**CITY OF MERCER ISLAND**

DEV17-001 review

February 23, 2017

RE: DEV17-001 Fence Height Deviation, 6753 WMW

LANDSCAPE PLAN

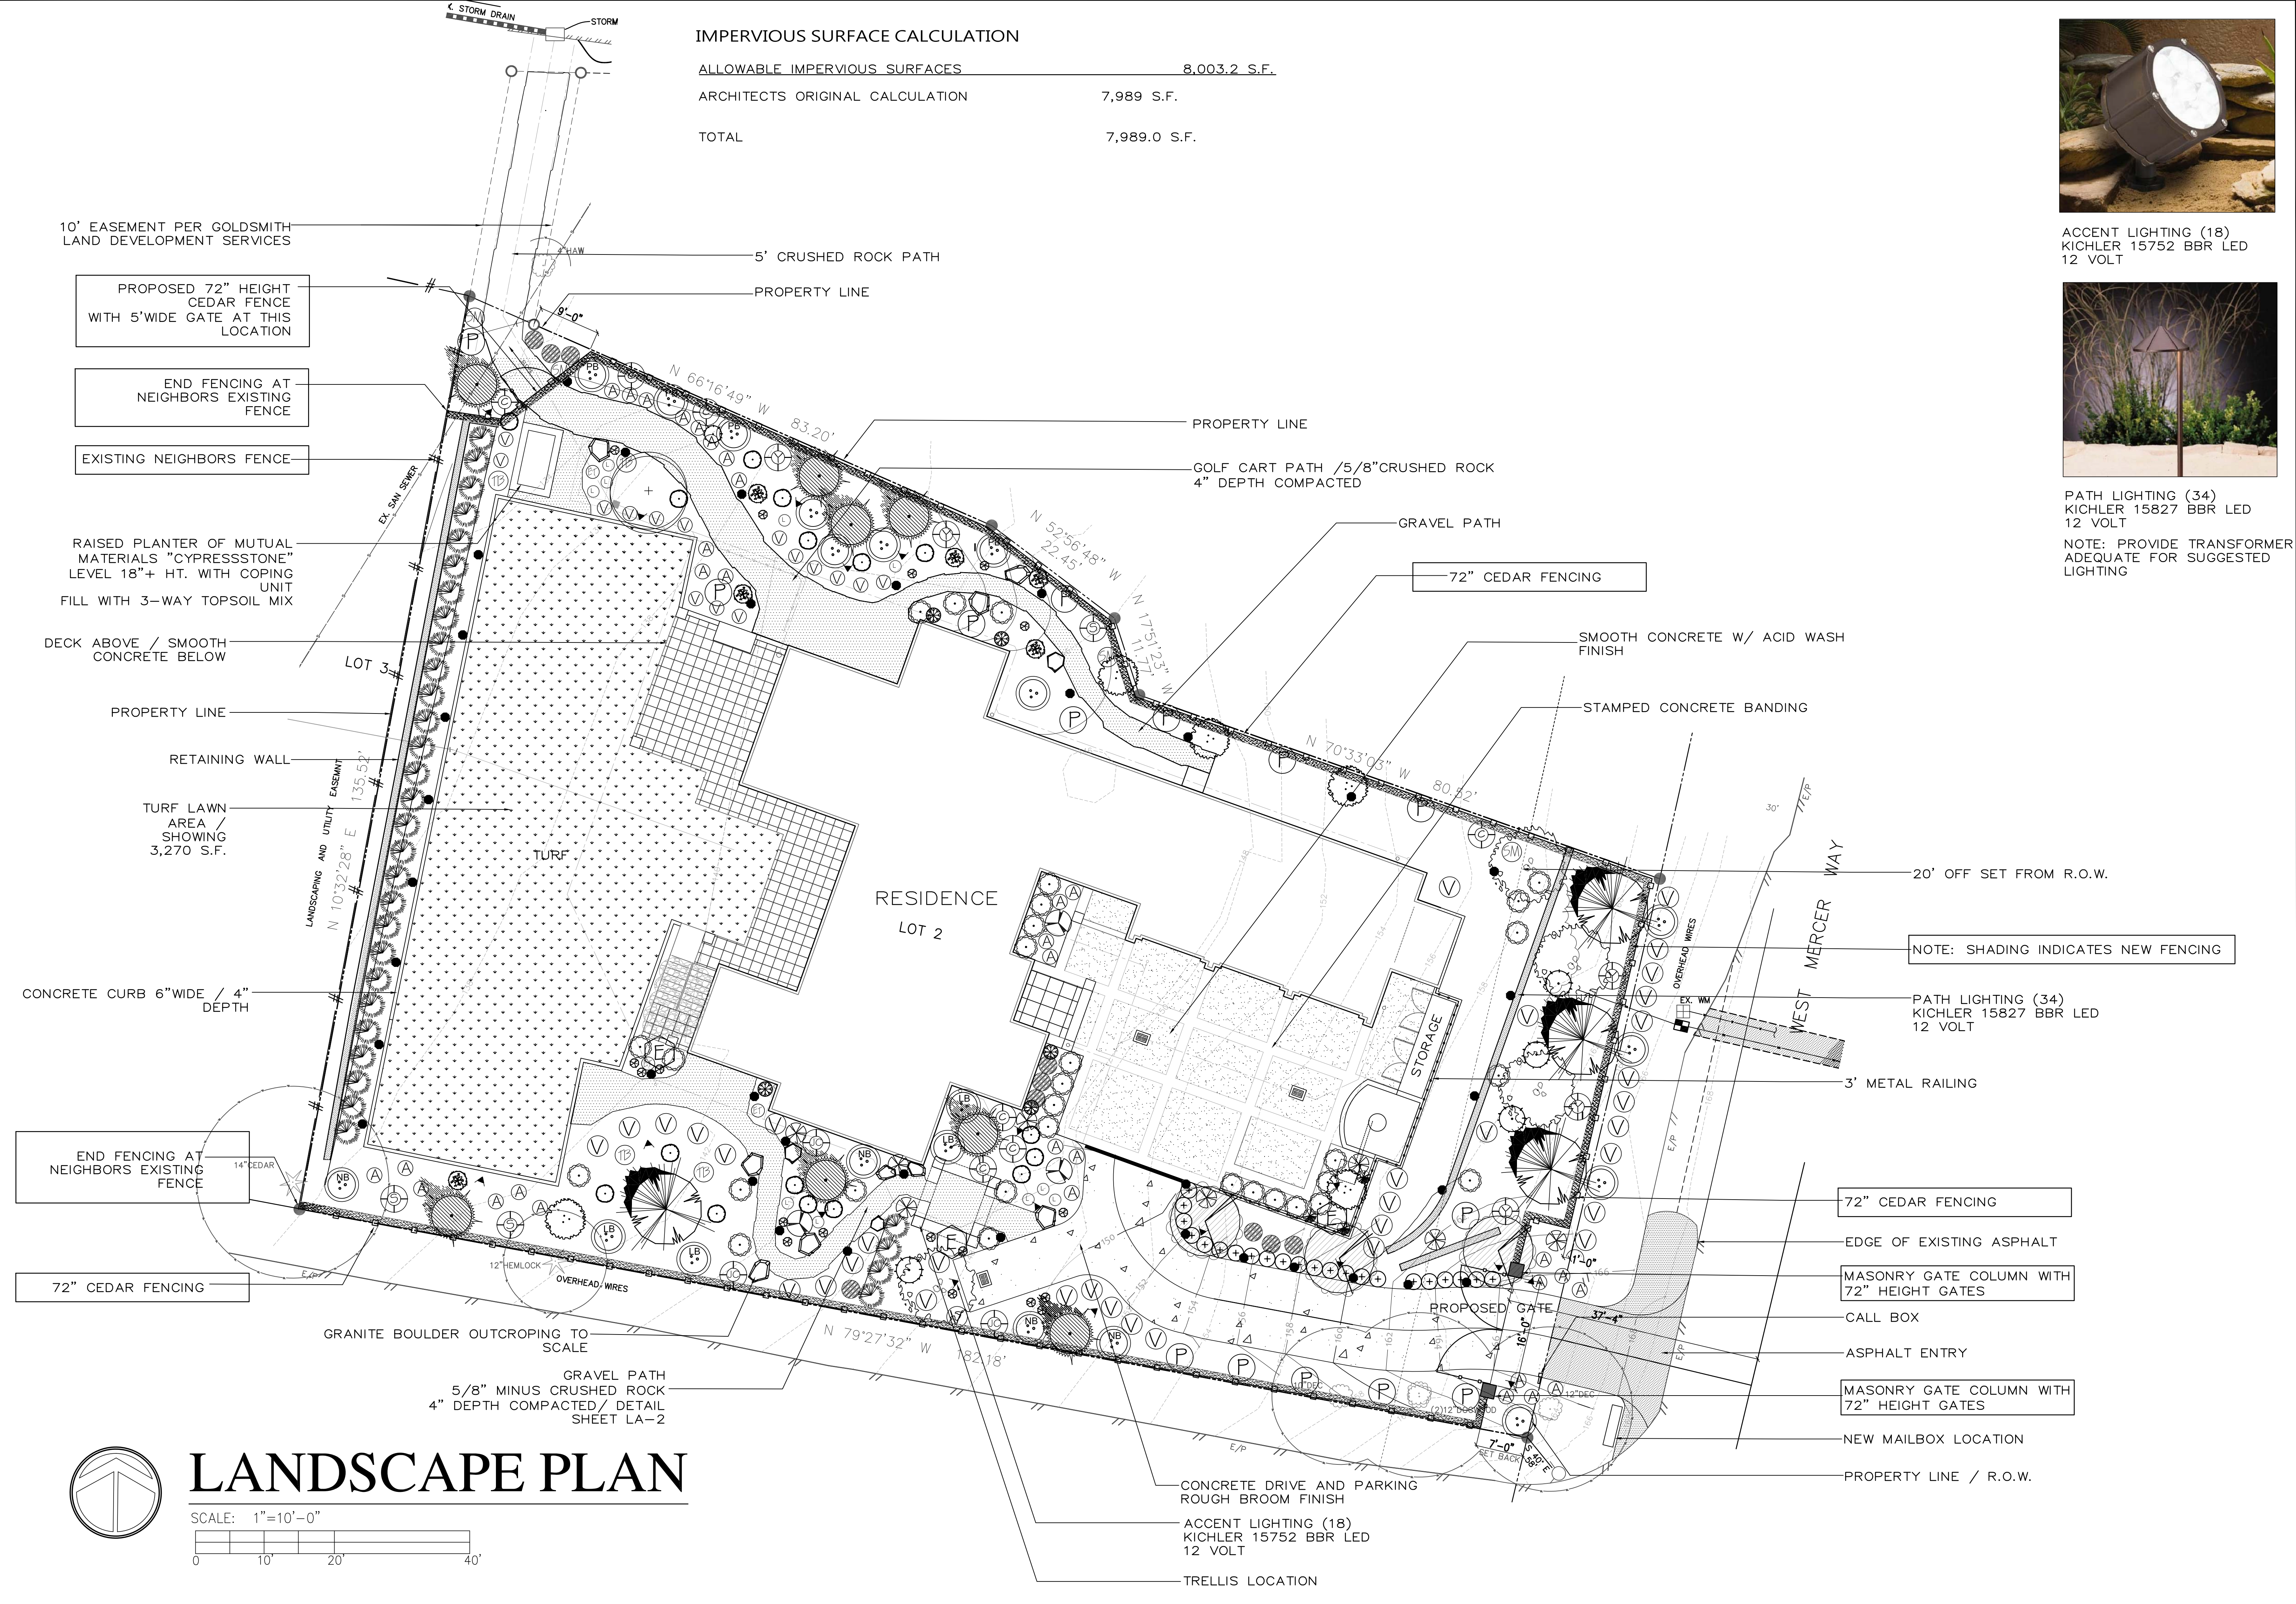
5. Please provide a rendering of what the 5 foot tall gate in the Northwest corner will look like.
6. Please provide a timeline for installation/completion of the proposed vegetation plan (as shown on the fence/gate site plan). Multiple Public Comments have expressed concern of the loss of vegetation and trees on the lot for development.

7. Please confirm that the proposed fence post locations won't have a negative impact on the surrounding trees, in regards to the roots and dripline. The City Arborist requires that the posts that could impact tree roots be moved. In addition, he recommends vegetation in front of the proposed fence as long as it stays out of the City Right-Of-Way.
